KITTITAS COUNTY FIRE MARSHAL'S OFFICE

Fire Marshal comments
Case Number: SP-23-00010

Zach Torrance-Smith, Project Planner

SHEET 1 OF 3

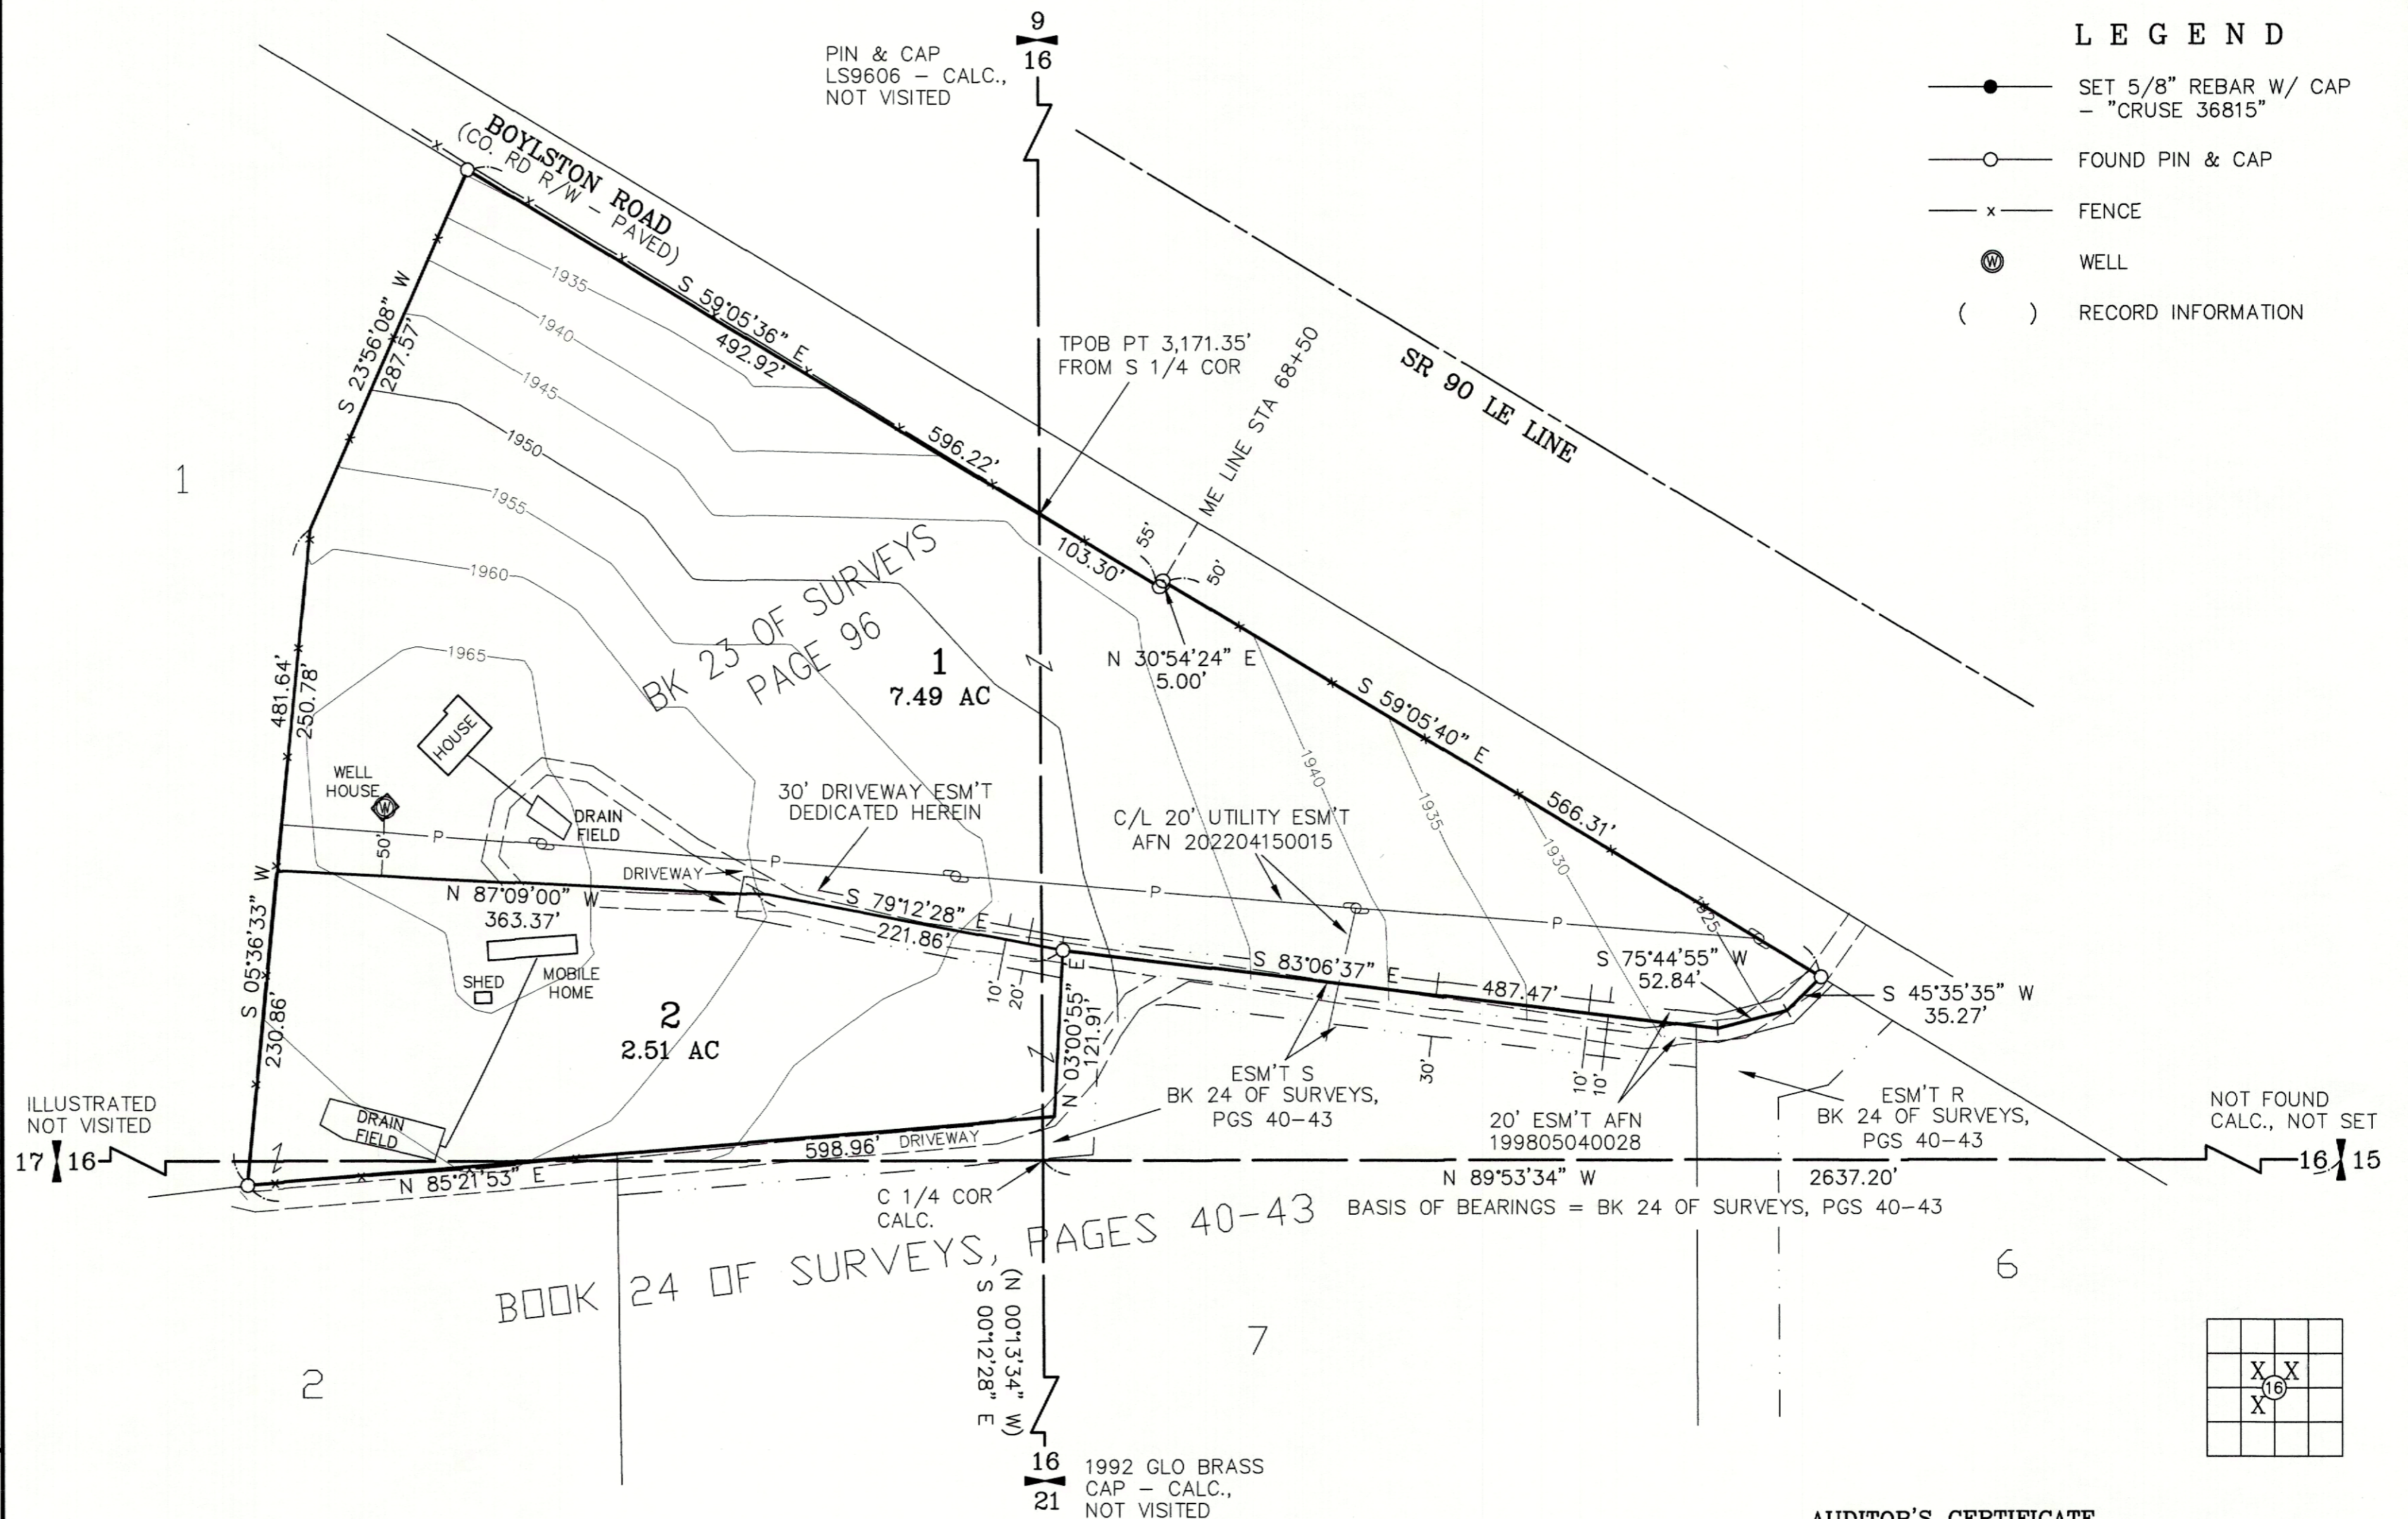
Approved fire apparatus turnarounds are required for this project. The indicated provisions for turning around fire apparatus are not adequate. Provide a turnaround meeting the requirements of the International Fire Code Appendix D.
